Public Rights of Way & Access Service
West Kent PROW
8 Abbey Wood Road
Kings Hill
West Malling, ME19 4YT

Web site: www.kent.gov.uk
Phone: 03000 41 71 71
Ask for: Nicky Biddall
Email: nicky.biddall@kent.gov.uk
Your Ref: SE/20/03750/FUL
Our Ref: PROWAS/20/NJB/SR19/a00910
Date: 13th January 2021

Subject: **PLANNING APPLICATION REF: SE/20/03750/FUL**
Site: Preston Farm Shoreham Road Shoreham TN14 7UD
Development: Conversion and replacement of existing buildings to create a new rural business work hub.

Figure 8: Masterplan

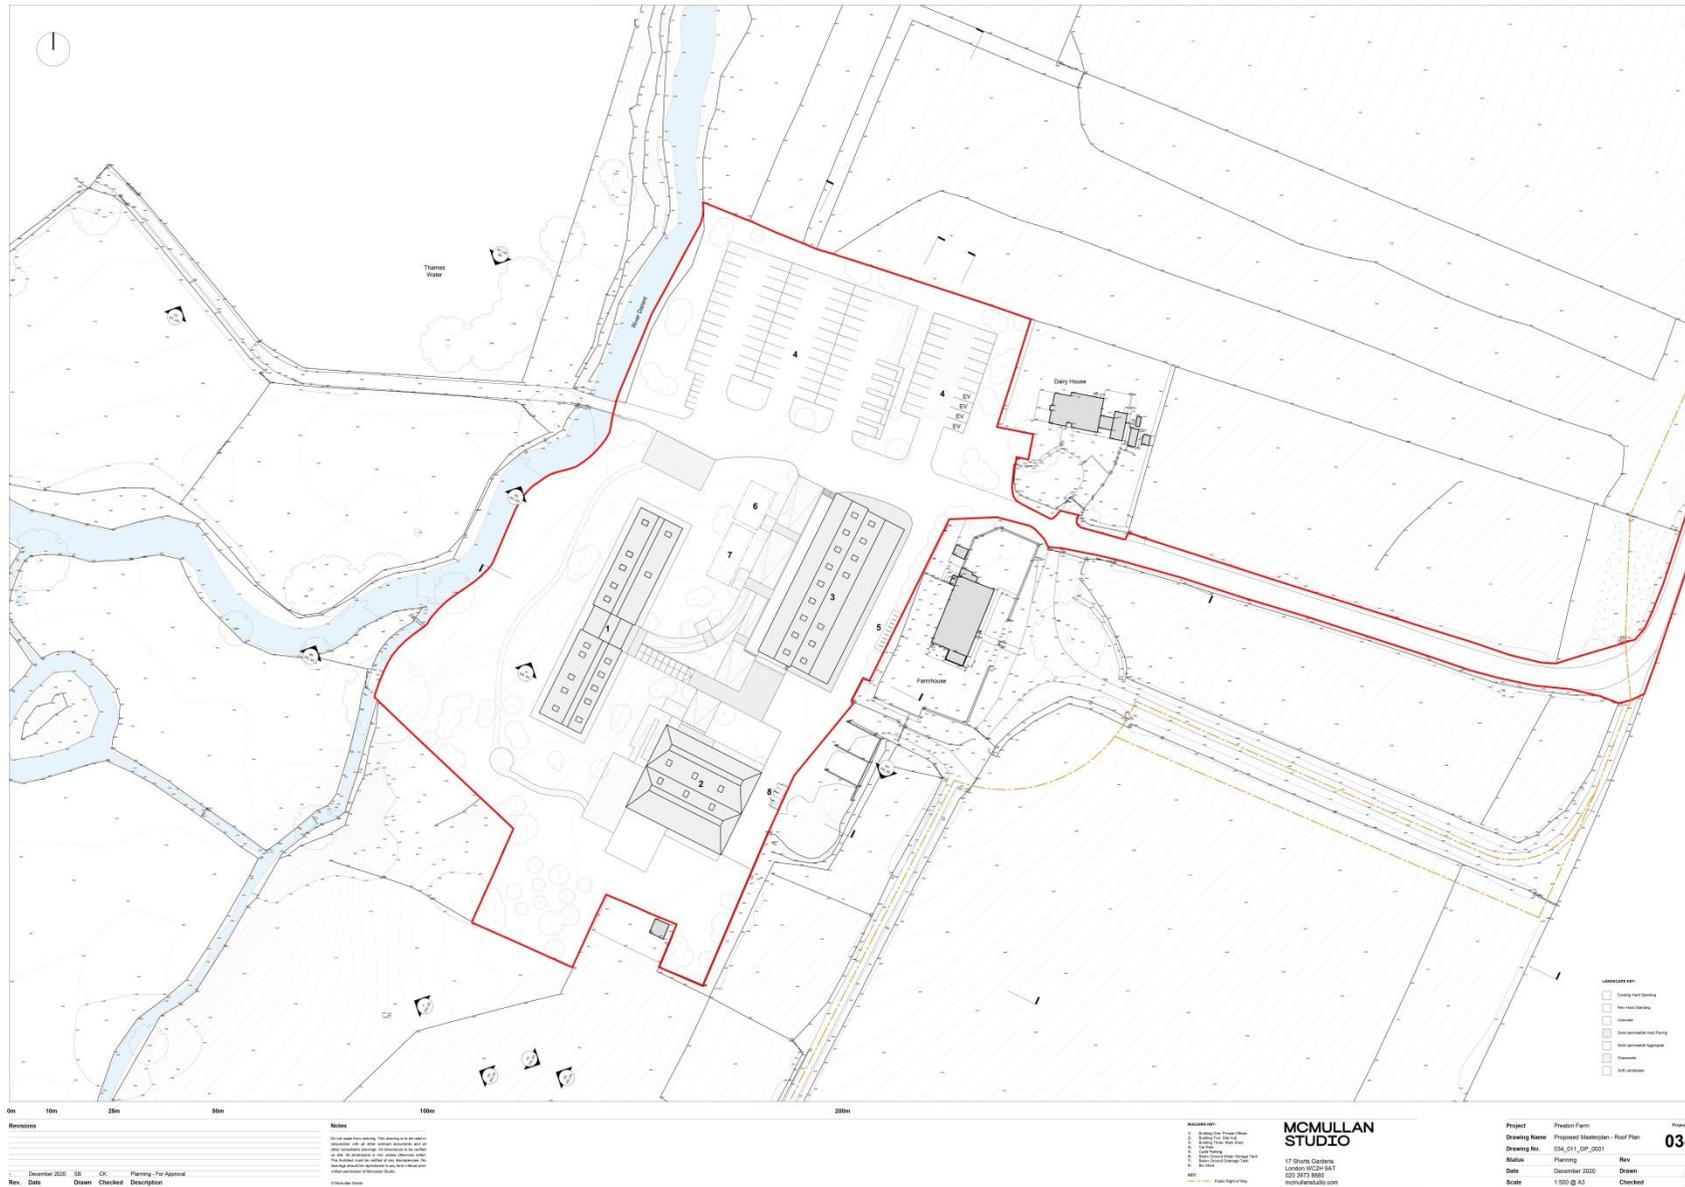
I am concerned that this project will result in an increase in the traffic crossing the footpath, but I have been unable to find any proposals to ensure the safety of walkers in the documents. This needs to be considered and details provided. For example, the present gate could be set further into the field to ensure there is a space off the road for walkers to wait safely, there could also be a restriction in height on the hedge to ensure visibility to both walkers and drivers.

It would also be appropriate for the applicant to mitigate these negative impacts by improving the surface of SR19 on land within his ownership. The Public Rights of Way and Access Service can be contacted for further details.
